**WELWYN HATFIELD BOROUGH COUNCIL
EXECUTIVE DIRECTOR - PLANNING, PUBLIC PROTECTION AND GOVERNANCE**

Application No: 6/2020/2857/FULL
Location: 73 Pine Grove Hatfield AL9 7BL
Proposal: Erection of 2 x three storey semi-detached houses following demolition of existing detached bungalow; re-submitted revision of Planning Approval 6/2018/0215/FULL to regularise siting relative to neighbours as begun to be built.
Officer: Mr Raymond Lee

Recommendation: Granted

Drawing Number 73PG-07	Revision F
----------------------------------	----------------------

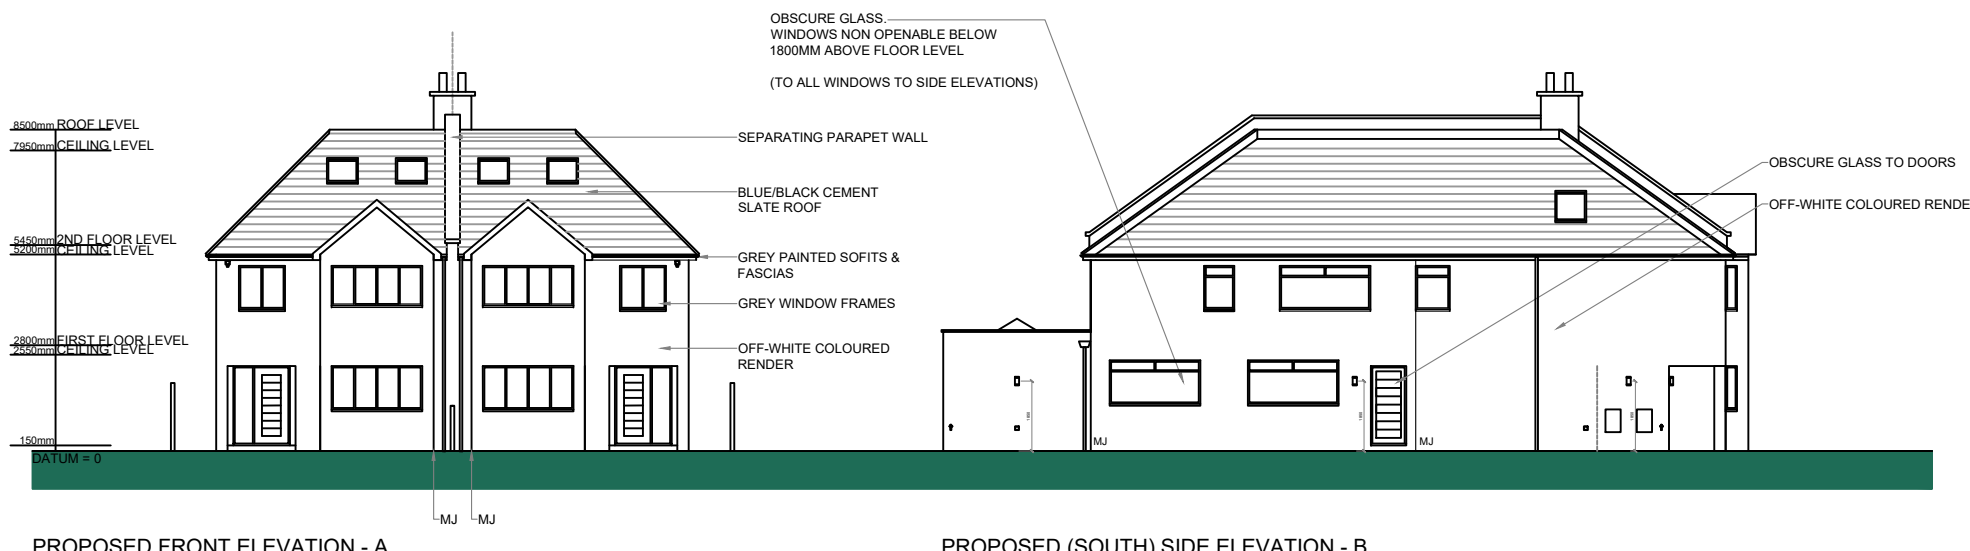
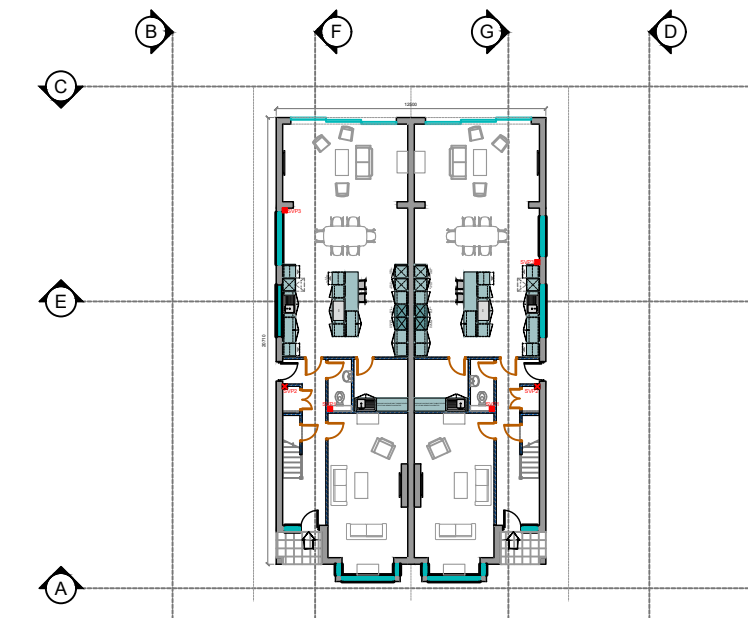
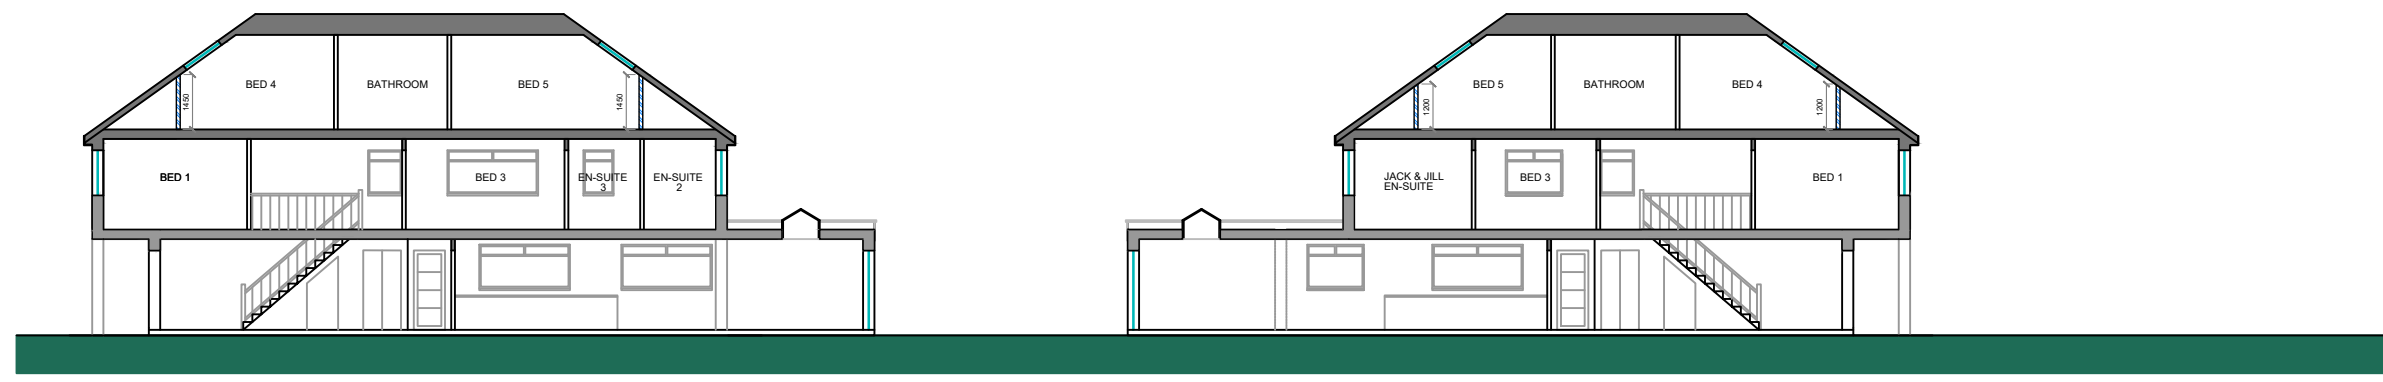
This is a two-storey detached dwelling located to the immediate south of the proposed development. The two-storey element of the proposal would extend approximately 3.1 metres beyond the rear wall of this dwelling and the single storey element by an additional approximate distance of 3.9 metres. The single storey element would have a height of 3.1 metres.

As for the impact upon their privacy, since there will be three first floor windows serving an en-suite, bedroom and hallway and a rooflight serving a bedroom that would face the flank wall and flank window of this adjacent property, it is considered reasonable and necessary to ensure (via planning condition) that the openings are fixed and obscure glazed above 1.7 metres internal floor level.

2. Any upper floor window located in a wall or roof slope forming a side elevation of the development hereby approved must be obscure-glazed and non-opening unless the parts of the window which can be opened are more than 1.7 metres above the floor of the room in which the window is installed, and shall be retained in that form thereafter.

Drawing Number 73PG-11	Revision K
---------------------------	---------------

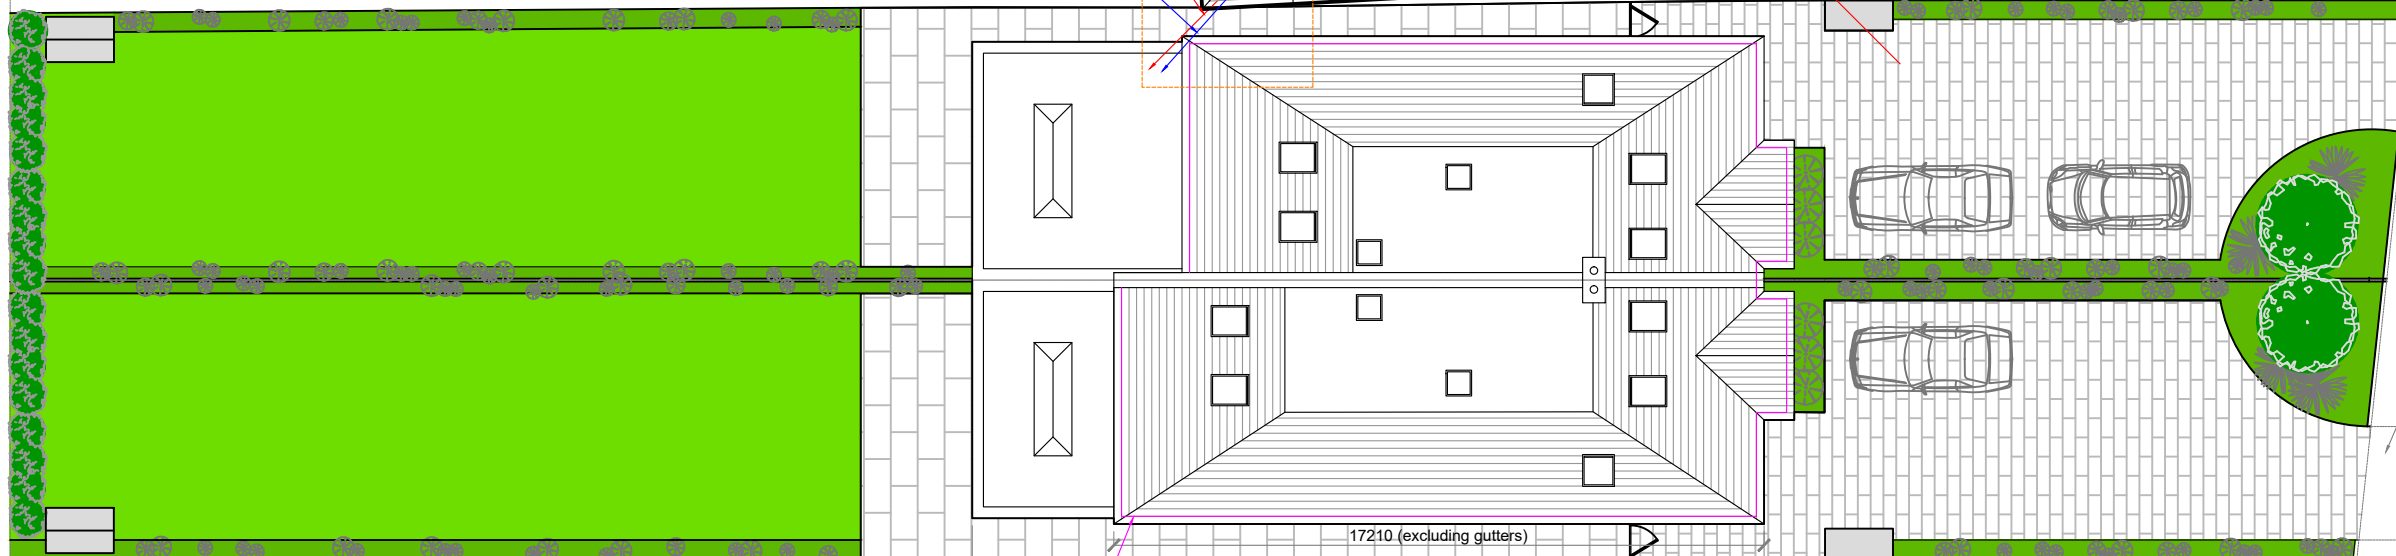
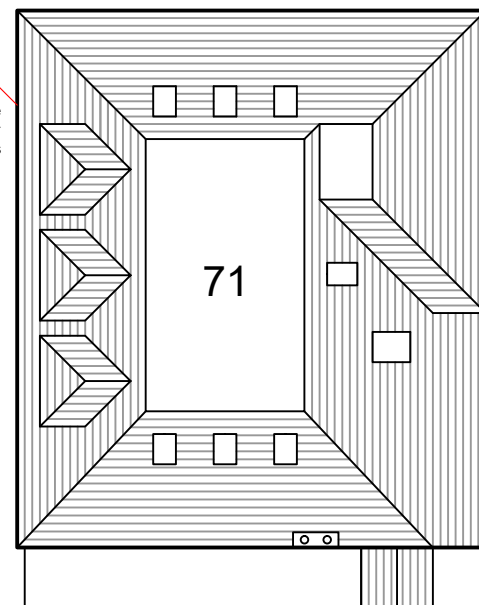
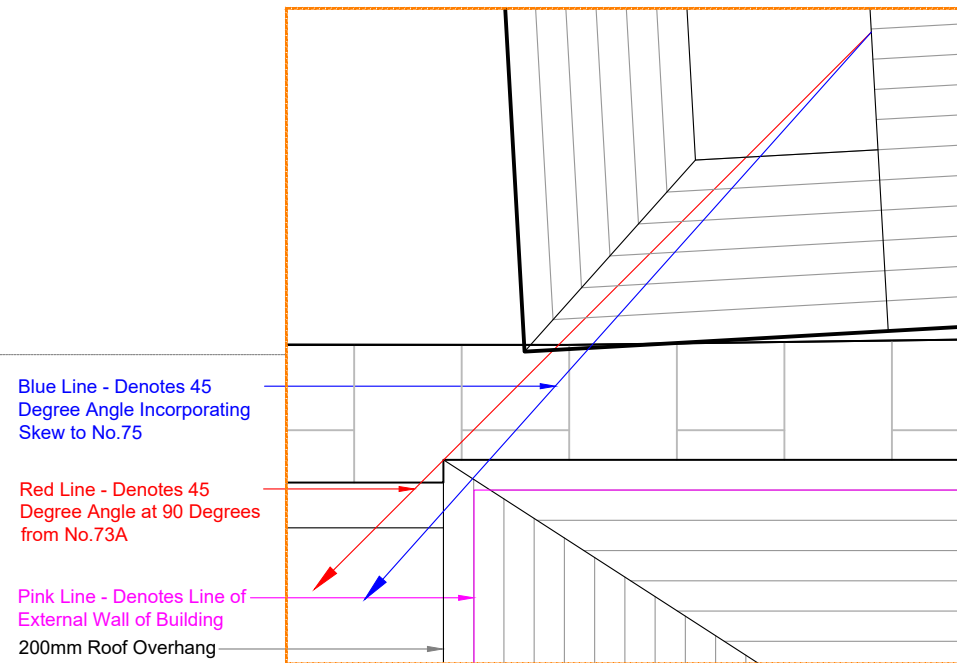
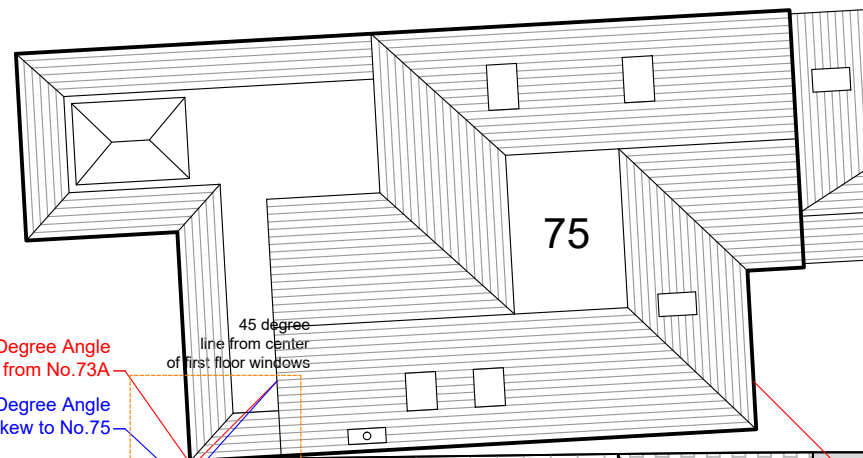
As mentioned above, the current scheme now proposes a reduction in the depth at first floor level. In assessing the impact on daylight, the applicant has indicated on the submitted plans that the development will now pass the 45 degree light test to neighbour's master bedroom window. The neighbours have however disputed the accuracy of the 45 degree line. It was stated that due to the fact that the rear of No.75 is skewed towards the application site a further reduction to the first floor projection is required. However it is understood that the sight line shown on the proposed drawing is on a roof plan and the proposed roof has an overhang of approximately 200mm. The applicant has subsequently amended the plan to show the 45 degree line taken from the proposed external wall of the building to demonstrate that the development

<p>passes the light test and would not result in detrimental overshadowing of No. 75's primary window.</p> <p>In terms of impact on outlook, the two-storey element of the previous refused scheme projected approximately 4.8 metres beyond the rear wall of No. 75 and 2.4 metres beyond the ground floor rear wall of this property. The scheme has now been reduced to approximately 3 metres and 0.6 metres respectively which would be comparable to the approved scheme. As such the proposal will now only see a marginal increase in additional depth which together with the circa 1 metre set in from the boundary would ensure that the development would not be unduly dominant to warrant a refusal.</p> <p>As identified in the previously refused application, the single storey element would see an increase in projection however the height and set-back distance would mitigate any adverse impact upon the outlook of No.75. The existing boundary treatment would also serve to reduce its visual impact when viewed from the neighbour's side.</p> <p>Consequently, for above reasons, the proposed reduction in the depth of the first floor element would overcome the previous harm identified to the living conditions of the occupiers of No.75 in terms of light and outlook.</p> <p>In terms of privacy, no changes have been proposed to the positioning of the windows and rooflight that faces the flank wall and flank window of this adjacent property. As such it is considered necessary and reasonable to impose an obscure glazing condition upon approval to maintain the privacy of No. 75.</p>
